**J. SMITH STRUCTURAL ENGINEERING, PLLC**  
N.C. CERTIFICATE NUMBER P-2212

February 14, 2024

**RE:** 620 Rollins Mill Road  
Holly Spring, North Carolina  
As-built footings

**S-1  
 CRAWL SPACE  
 FOUNDATION PLAN**

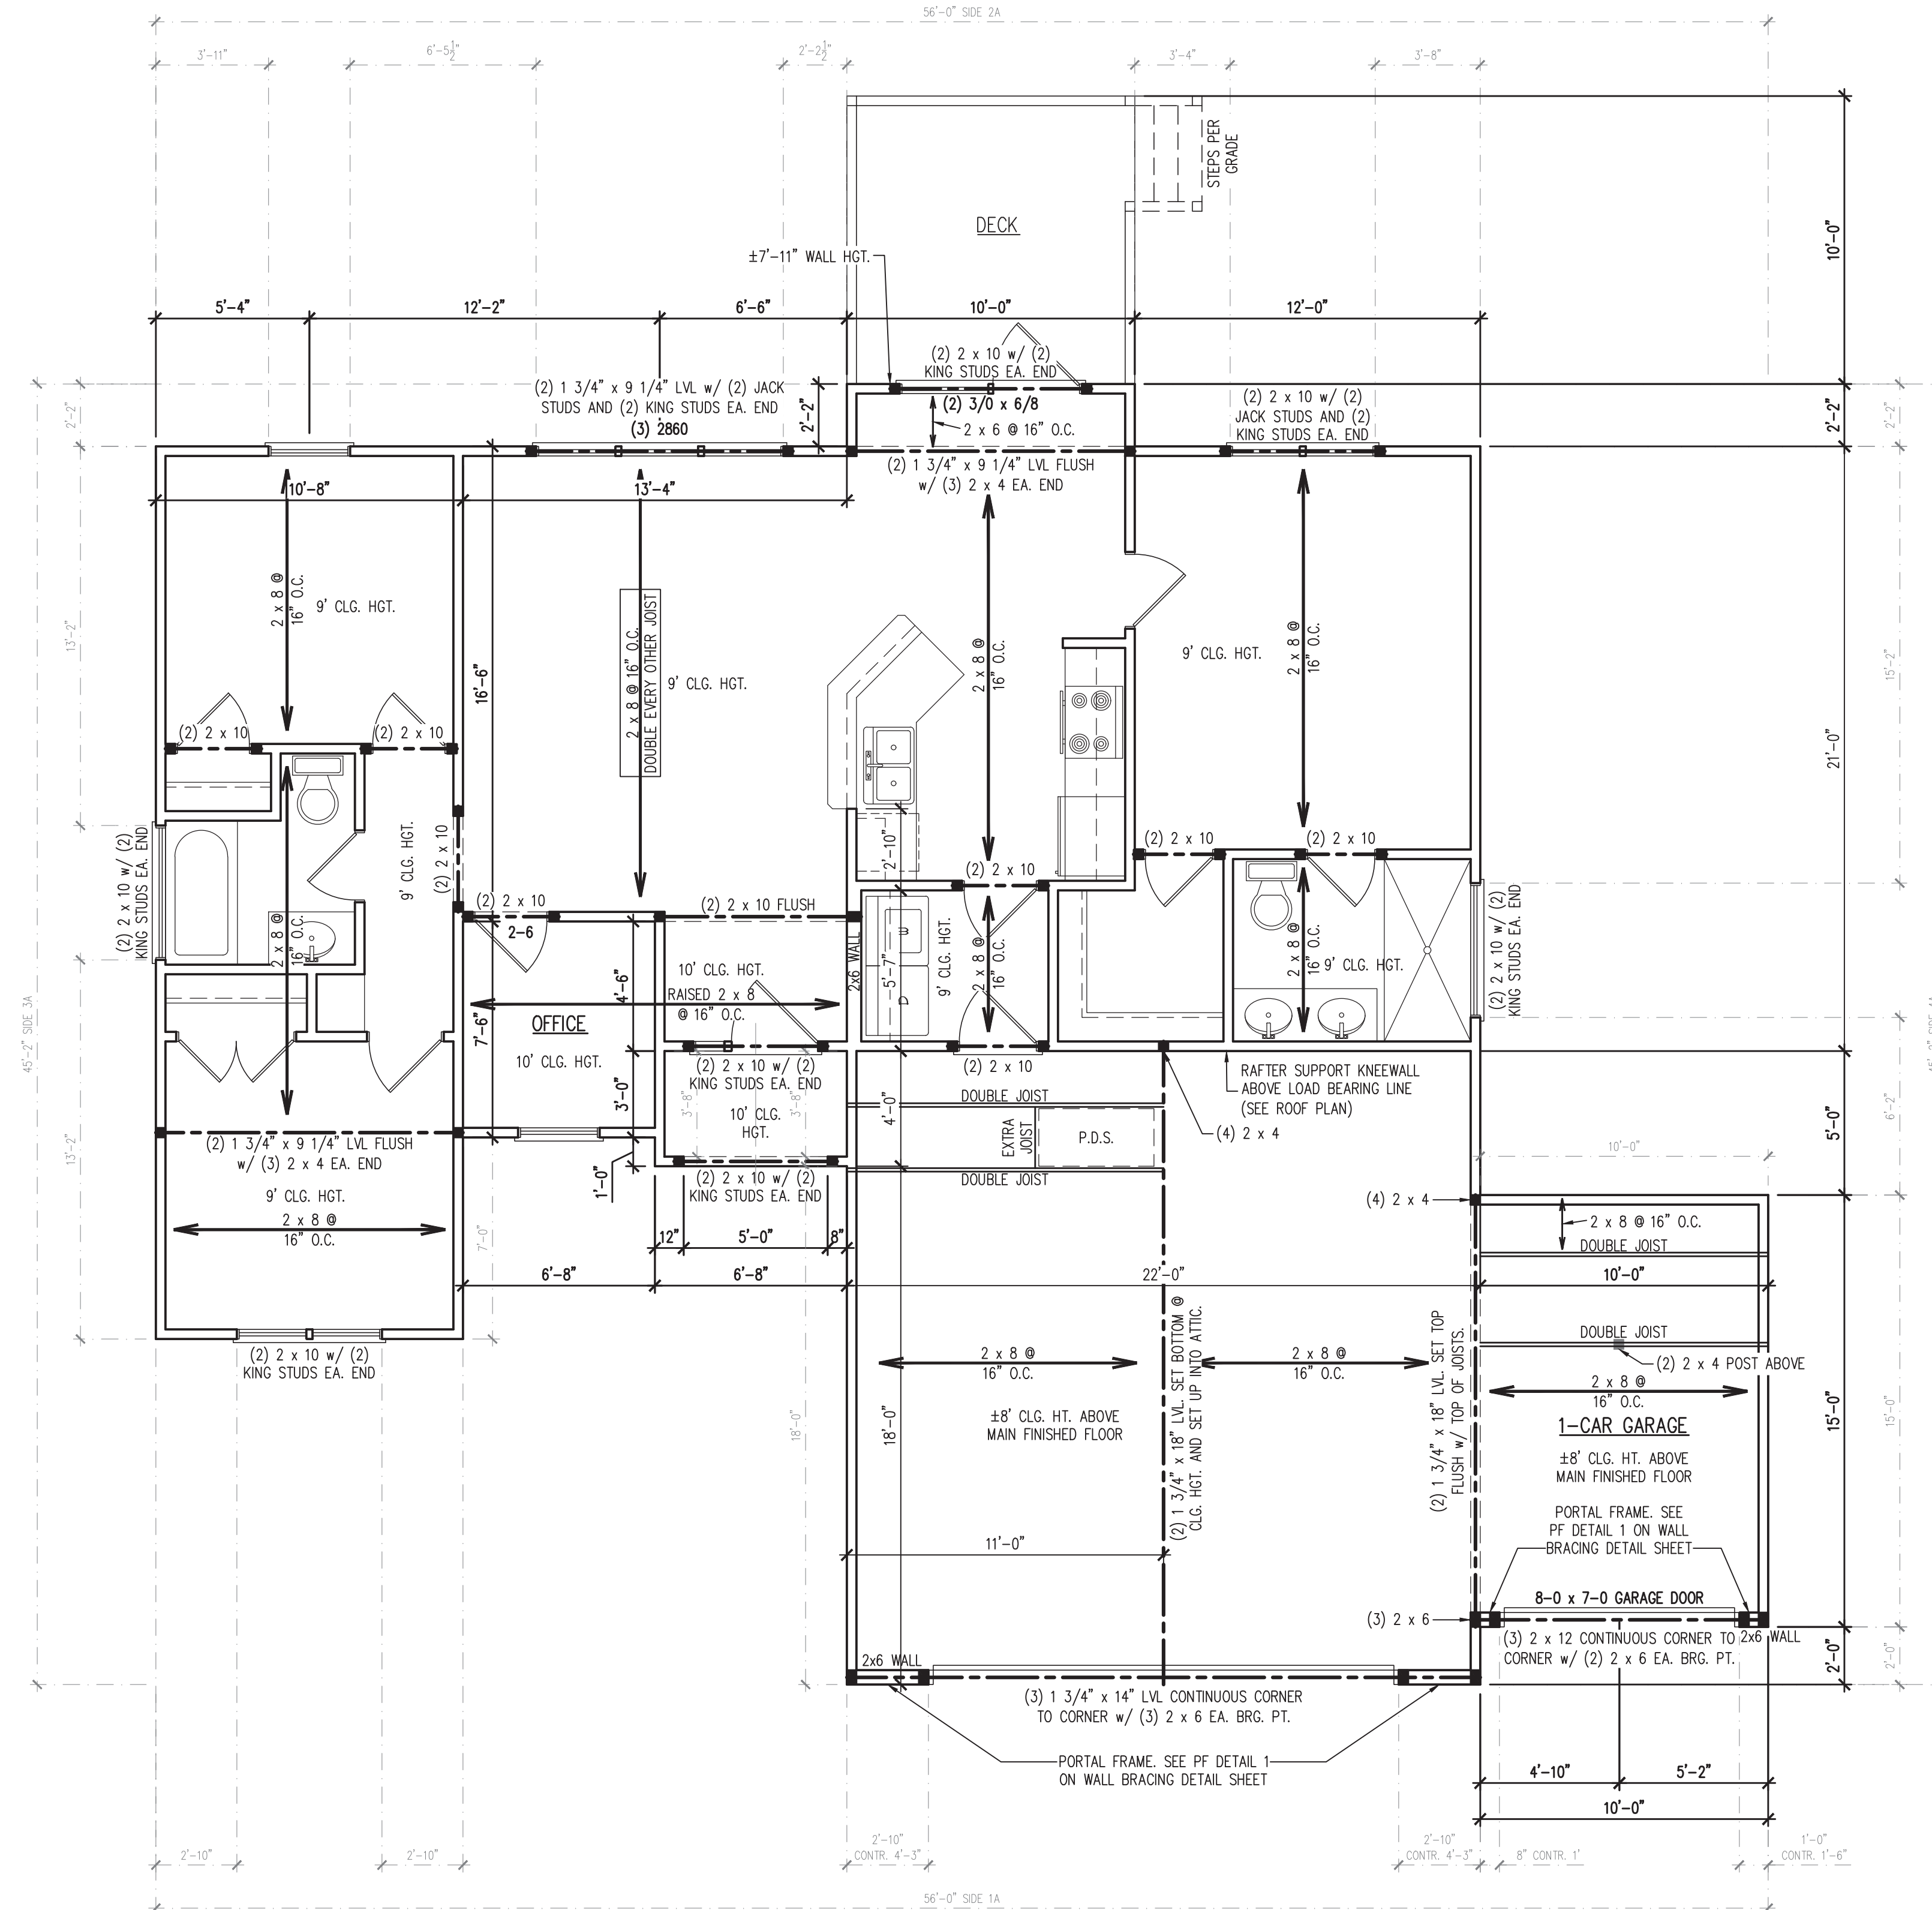
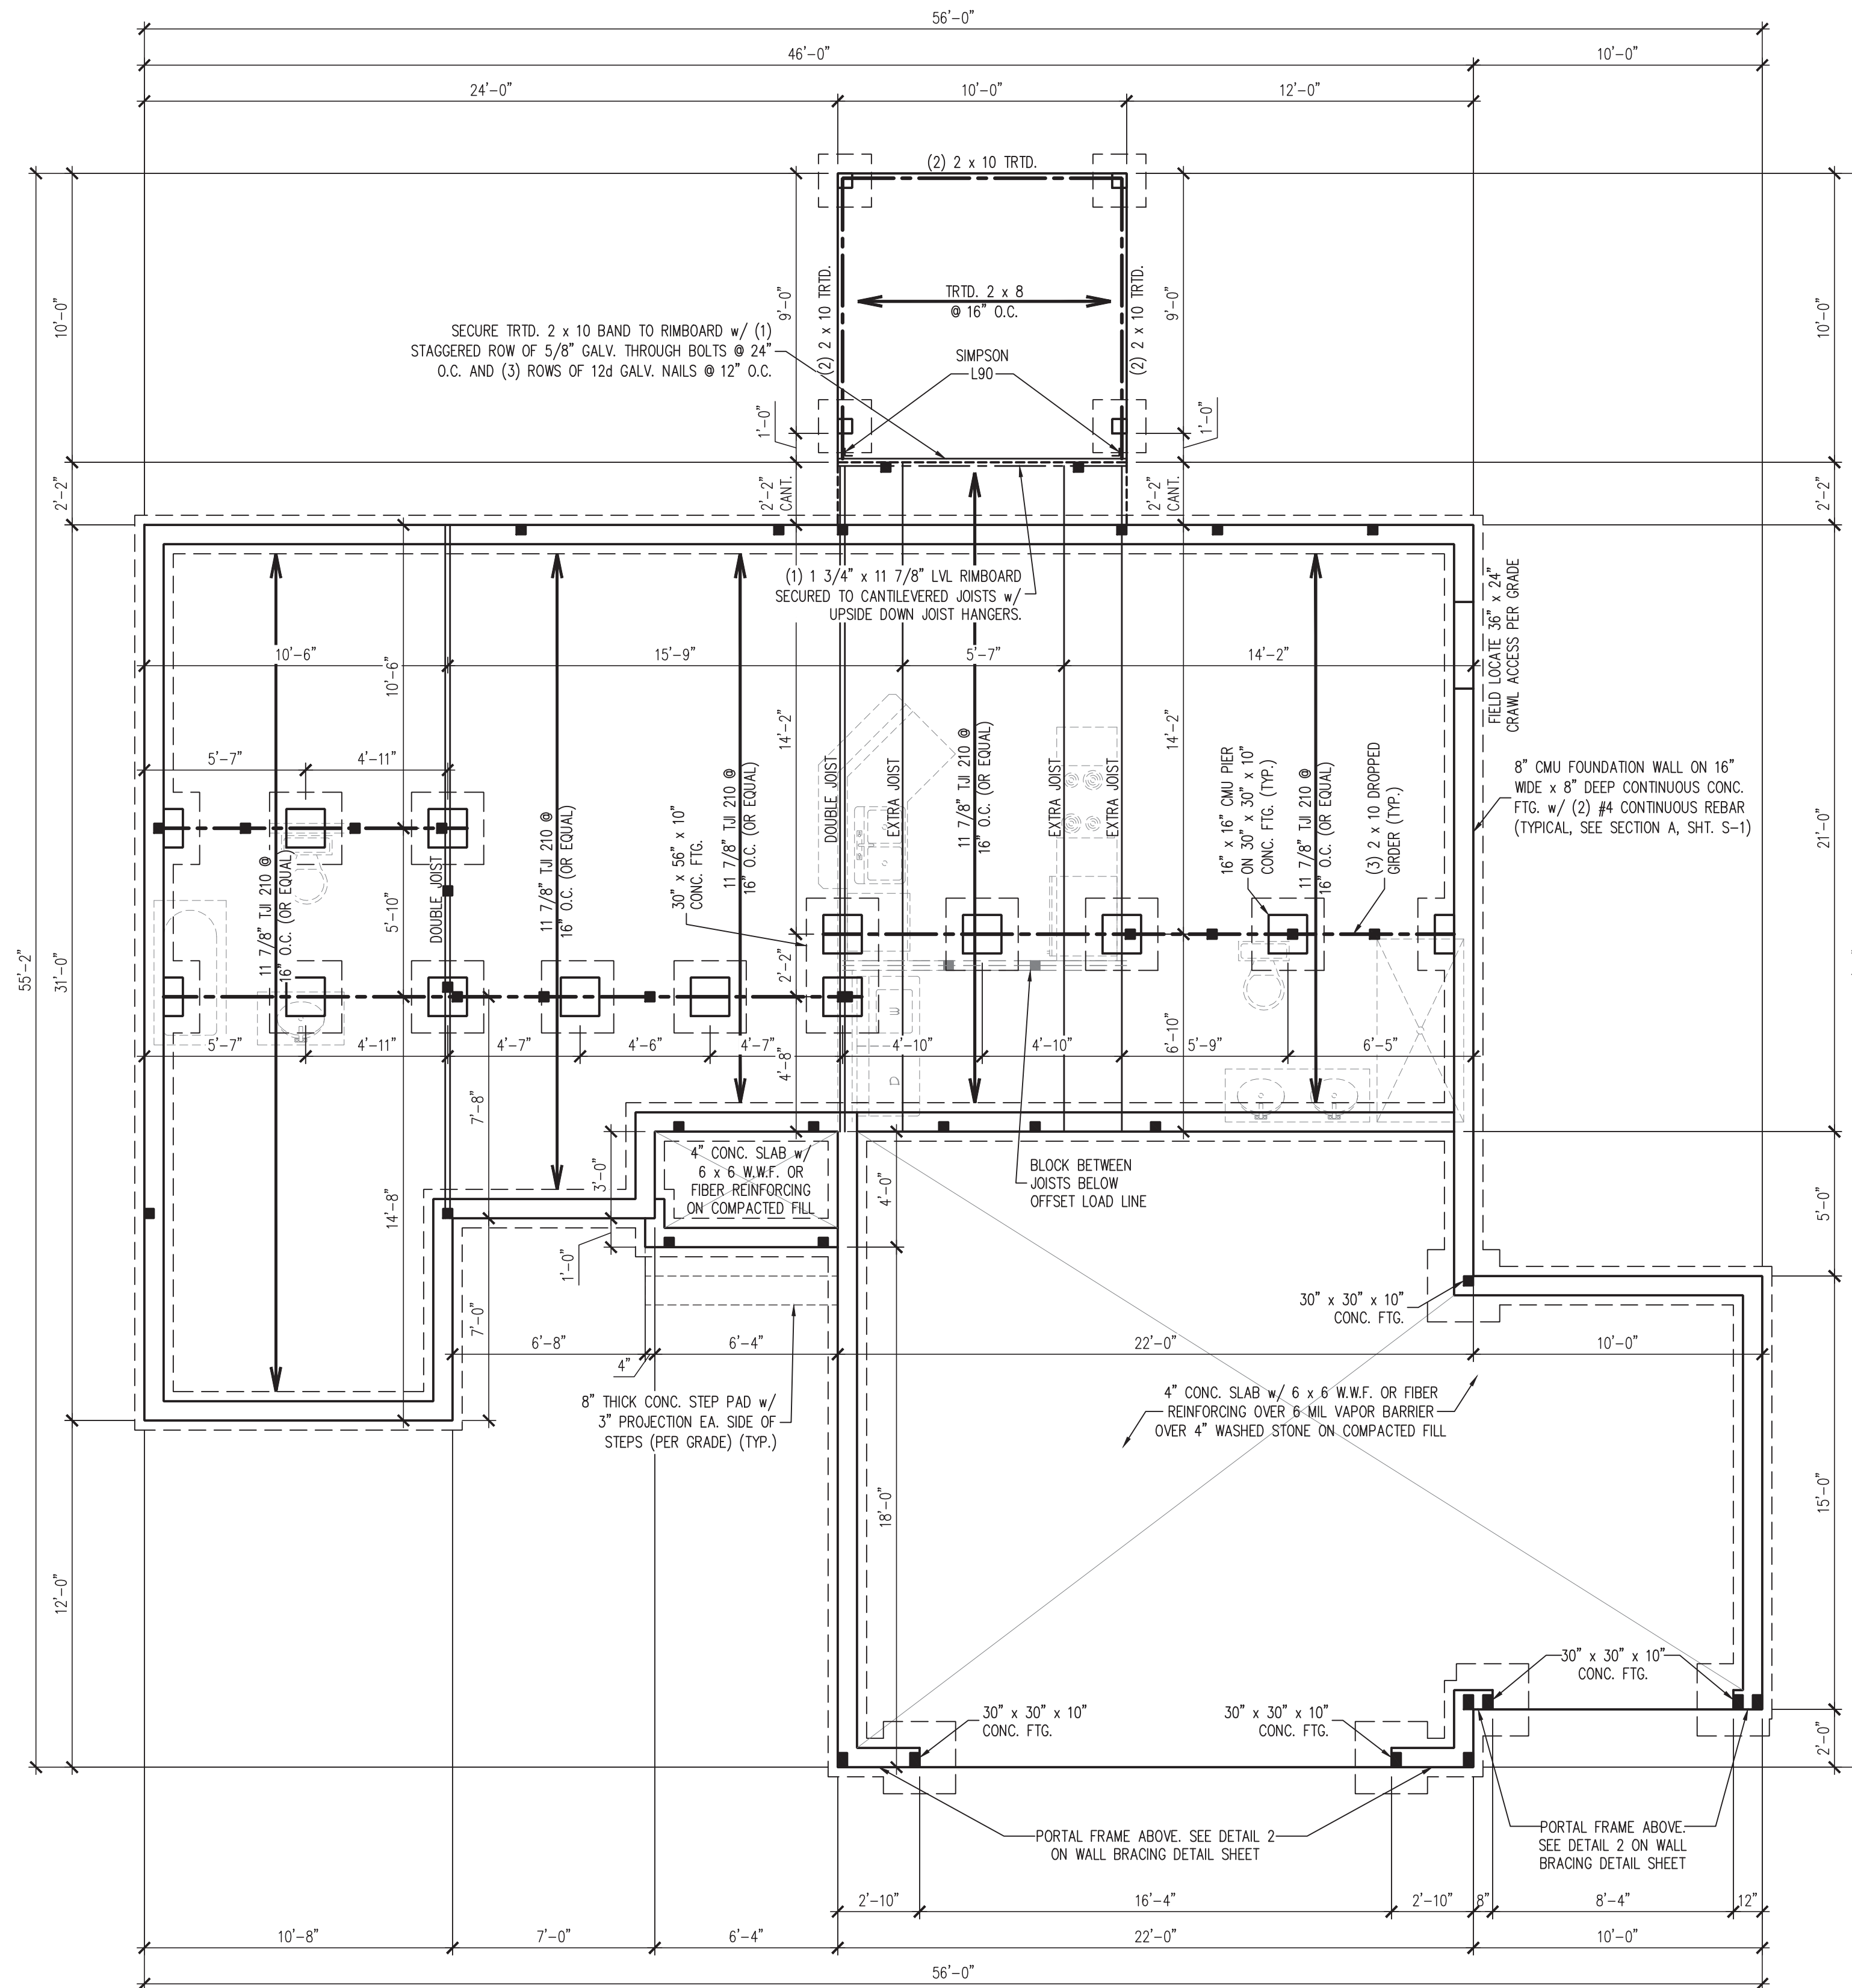
The above reference plans were reviewed to address the as-built footing construction. The engineered drawings specified an 8" CMU crawl space foundation on a 16" wide x 8" deep continuous concrete footing with (2) #4 continuous rebar. You indicated that the (2) #4 continuous rebar were not installed in the continuous crawl space footings. While I recommend placing the rebar in all continuous footings for long term serviceability of the foundation system, the 2018 NCRBC does not require footing rebar in the crawl space walls and the rebar may be omitted per the builder's discretion.
